From: Edward Ledwidge [REDACTED]
Sent: 27 May 2015 11:46
To: Agency Dan McEwan
Subject: RE: Land South of New Road - A/23/15/OUT

Road Safety Audit Report

Proposed Access off the A259 New Road, Rustlington

Job no	RSA-15-002	Issue no	1	Date	April 2015
Prepared by	JJF	Verified by	AJB	Approved by	JJF
Filename and Path	Fenley/Road Safety Audits/RSA-15-002-01.doc

Title
HIGHWAY ACCESS PLAN

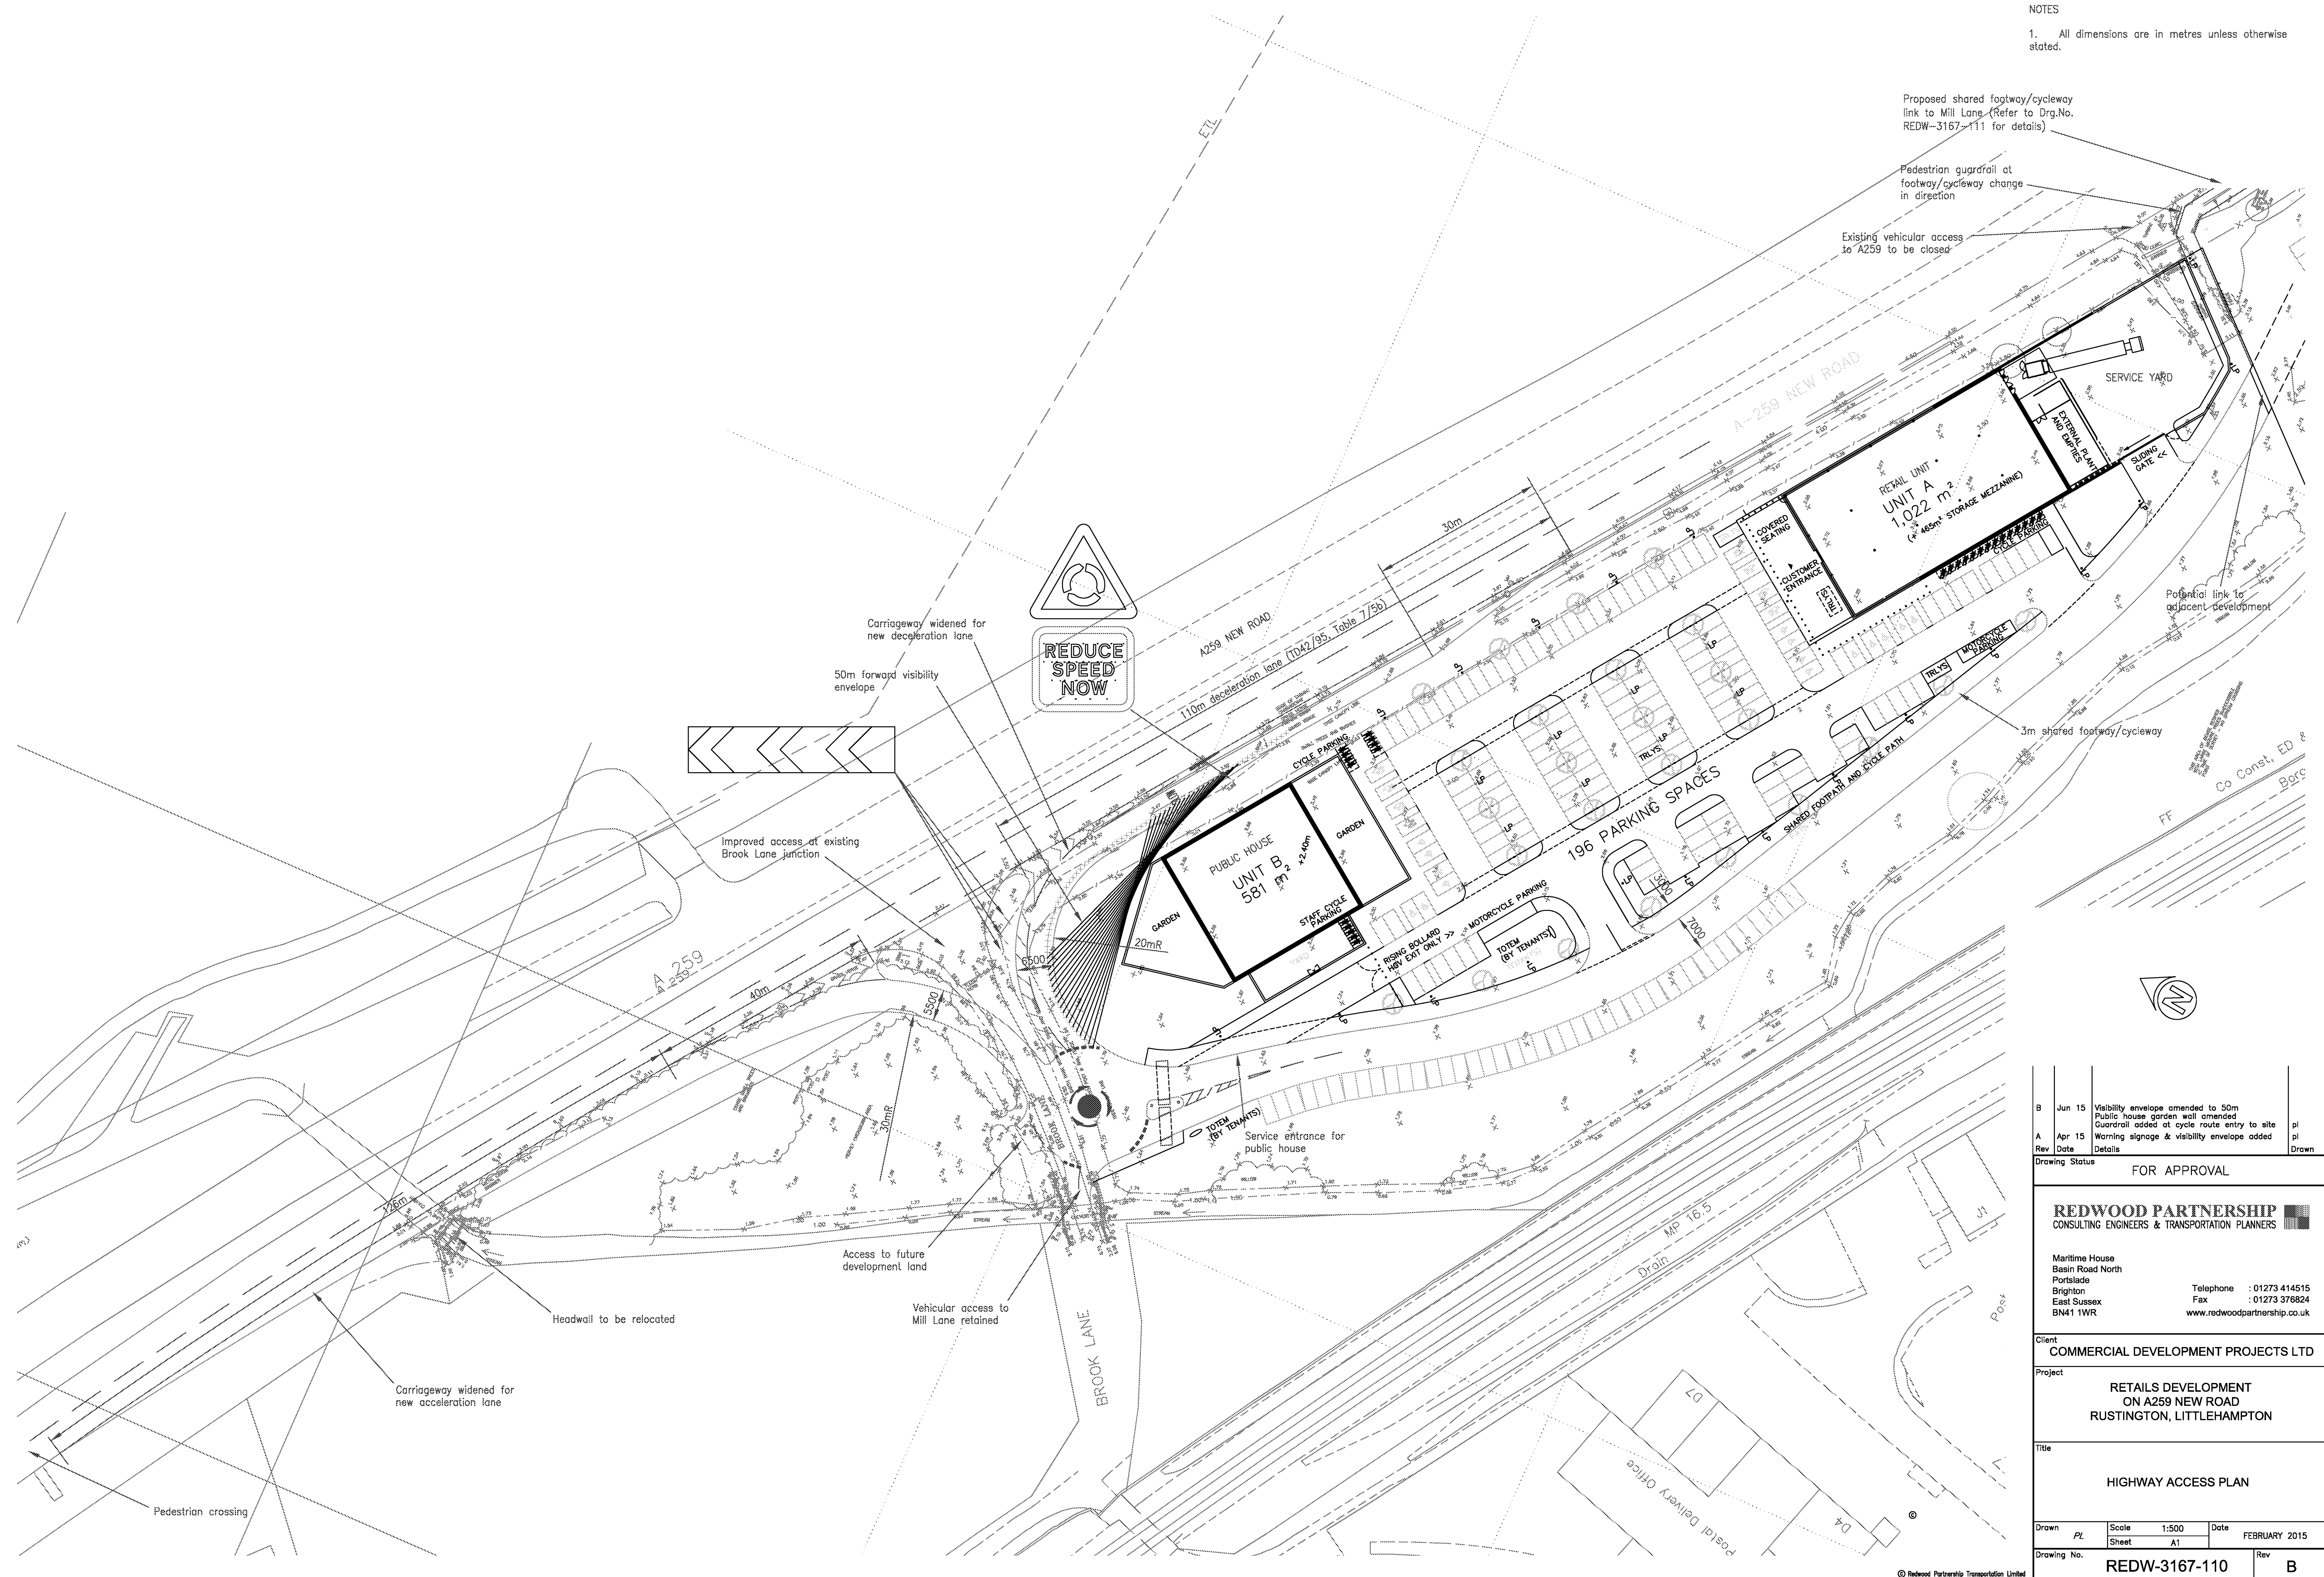
Audit Item No.	Audit Team Observation	Audit Team Recommendation	Designer / Scheme Response
A.1	GENERAL		
A.1.1	<i>The proposals to improve an existing access off the A259, New Road to facilitate the safe access and egress to / from a proposed development consisting of a food retail store and pub/restaurant at this location does not raise any road safety concerns in general at this stage, provided that the items raised within this audit in the following specific sections are addressed appropriately. The access road associated with the development is of sufficient length to allow for the free flow of vehicles off the A259 without the need to stop to allow vehicles to access and egress parking spaces.</i>		
A.2	LOCAL ALIGNMENT		
A.2.1	PROBLEM Tight entry corner radius Accident Type <i>Loss of Control</i> Location Entry radius from deceleration lane <i>The proposed deceleration lane is provided for vehicles to decelerate from the derestricted A259. Vehicles could therefore be travelling in excess of the speed required to safely manoeuvre around the 20 metre corner radius. This could result in vehicles losing control and striking the island.</i>	The appropriate chevron and warning signs should be installed in clear view of vehicles utilising the deceleration lane to ensure that drivers are aware of the corner. 	Chevron sharp deviation of route signs (Diag. 515) have been included on the central approach island as shown on Drg.No. REDW-3167-110-Rev A

Audit Item No.	Audit Team Observation	Audit Team Recommendation	Designer / Scheme Response
A.2.2	PROBLEM Restricted visibility around the exit corner radius Accident Type <i>Shunt</i> Location Inside of exit radius to the acceleration lane <i>Forward visibility vehicles accelerating from the roundabout to the acceleration lane to vehicles utilising the acceleration lane, is restricted by vegetation. Therefore drivers will not have a clear view of preceding vehicles. This could result in shunt type accidents should a driver hesitate and stop along the acceleration lane.</i> 	Vegetation should be cleared to the appropriate level to allow for the clear forward visibility.	Vegetation will be cleared to a distance of 3m from the kerb line of the site at the radius of the site egress. The verge area adjacent to the carriageway will be offered for adoption as Public Highway

Audit Item No.	Audit Team Observation	Audit Team Recommendation	Designer / Scheme Response
A.3	JUNCTIONS		
A.3.1	PROBLEM Forward visibility to the roundabout is restricted Accident Type Shunt type accidents Location Roundabout Forward visibility to the give-way road marking at the roundabout from the deceleration lane is restricted to approximately 50 metres based on the building line of the adjacent pub/restaurant. This could be further restricted should a fence be erected around the associated grounds and could result in shunt type accidents where vehicles are stopped at the give-way.	Warning signs should be installed to ensure that approaching vehicles are aware of the presence of the roundabout and the pub/restaurant should be restricted from erecting a fence where it blocks forward visibility. 	Forward visibility to the site roundabout is restricted due to a boundary wall proposed around the public house garden area. The achievable forward visibility envelope is shown on Drg.No. REDW-REDW-3167-110-Rev A. An advanced warning sign of roundabout ahead (Diag. 510) and REDUCE SPEED NOW supplementary sign (Diag. 511) and SLOW road marking is proposed in advance of the roundabout which will mitigate the reduced forward visibility to the roundabout give way
